DECISION DELEGATED TO HEAD OF PLANNING

Application No: H16-0110-22 **Applicant:** Mr & Mrs Hollis
Proposal: Single storey flat roof rear extension & internal alterations
Location: 14 Woolram Wygate Spalding
Terminal Date: 28th March 2022

| SCALE<br>AS labelled                                                                     | DRAWN BY:<br><b>JC</b> | SHEET:<br><b>0318/22/01</b>           |  |

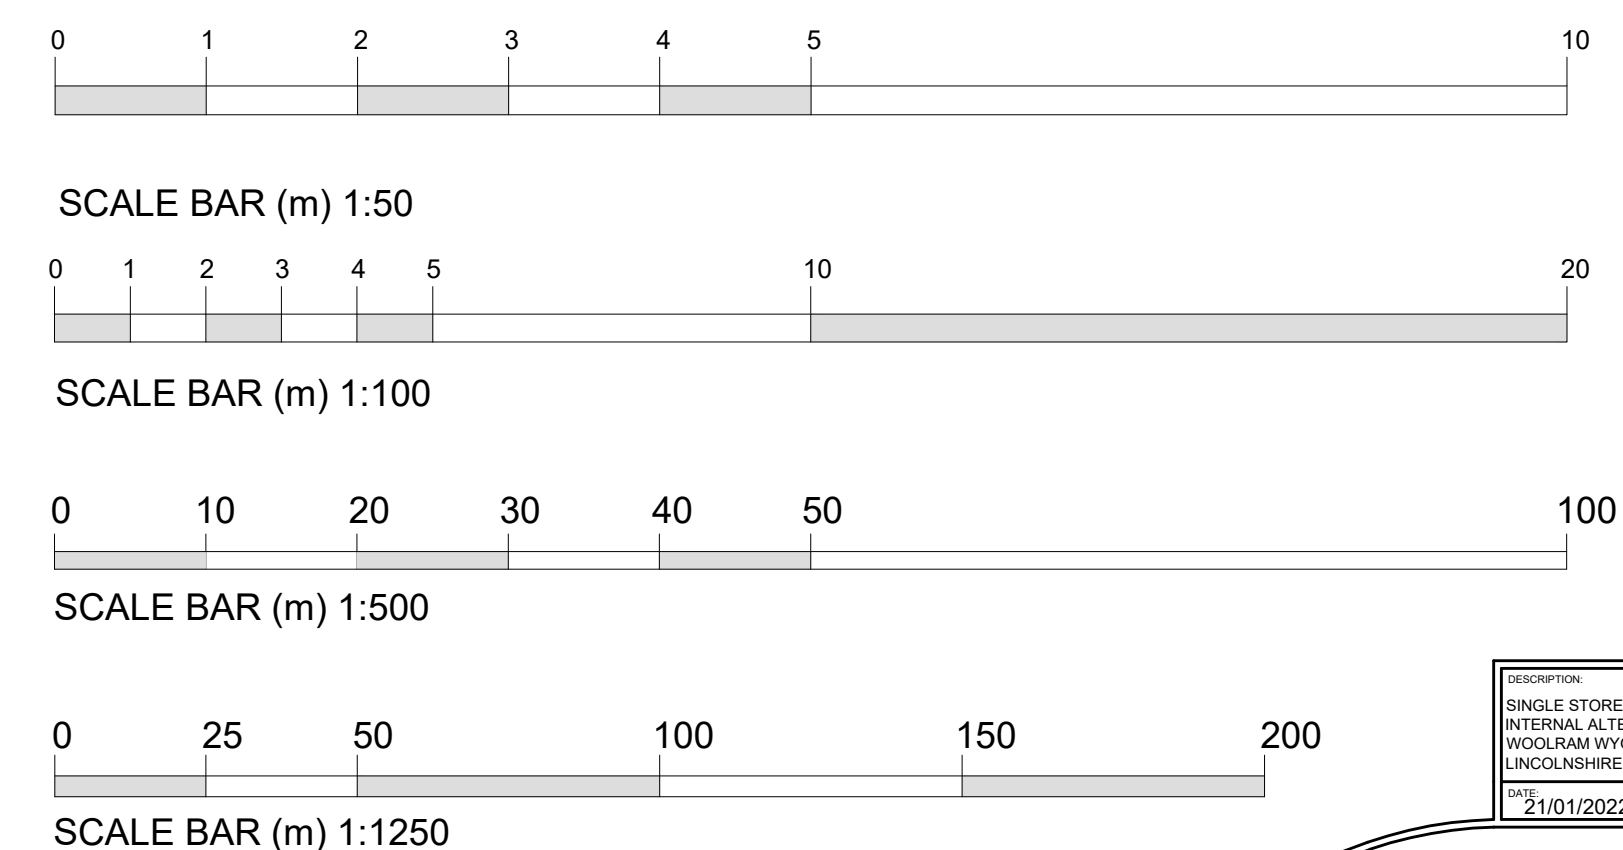
This is a householder application for a single storey flat roof rear extension & internal alterations at 14 Woolram Wygate, Spalding. The proposal seeks to provide an open plan kitchen / dining area, utility, bathroom, bedroom and a shower room en-suite. The extension would be 3.2 metres in height. The roofing material would be a GRP flat roofing system. Brick would be to match that of the existing dwelling and would be conditioned as such.

Overdevelopment - The proposal is not considered to represent overdevelopment. There is more than 12 metres in garden length beyond the rear elevation wall of the extension.

Overlooking - There is not considered to be an overlooking aspect from this ground floor extension. Finished floor levels are not raised and there are no side elevation windows, with the rear fenestration 12.119 metres from the 1.8 metre high fencing at the boundary.

Overbearing / overshadowing - There is not considered to be an overshadowing impact from the proposed extension. When right to light calculations are made to 16 Woolram Wygate to the north this dwelling is not affected due to the 3.2 metre flat roof height and the blank side elevation of the garage beyond the 1.8 metre high boundary fencing. When right to light calculations are made to 12 Woolram Wygate to the south this dwelling is not affected due to the 3.2 metre flat roof height and the extension being sited to the north of the rear elevation ground floor dining room beyond the 1.8 metre high fencing.

Due to the flat roof height of 3.2 metres and the siting to the rear of the dwelling, there is not considered to be a material impact on the character and amenity of the surrounding area. This application accords with Policies 1, 2 and 3 of the South East Lincolnshire Local Plan, 2019, as well as Section 12 of the National Planning Policy Framework, 2021.
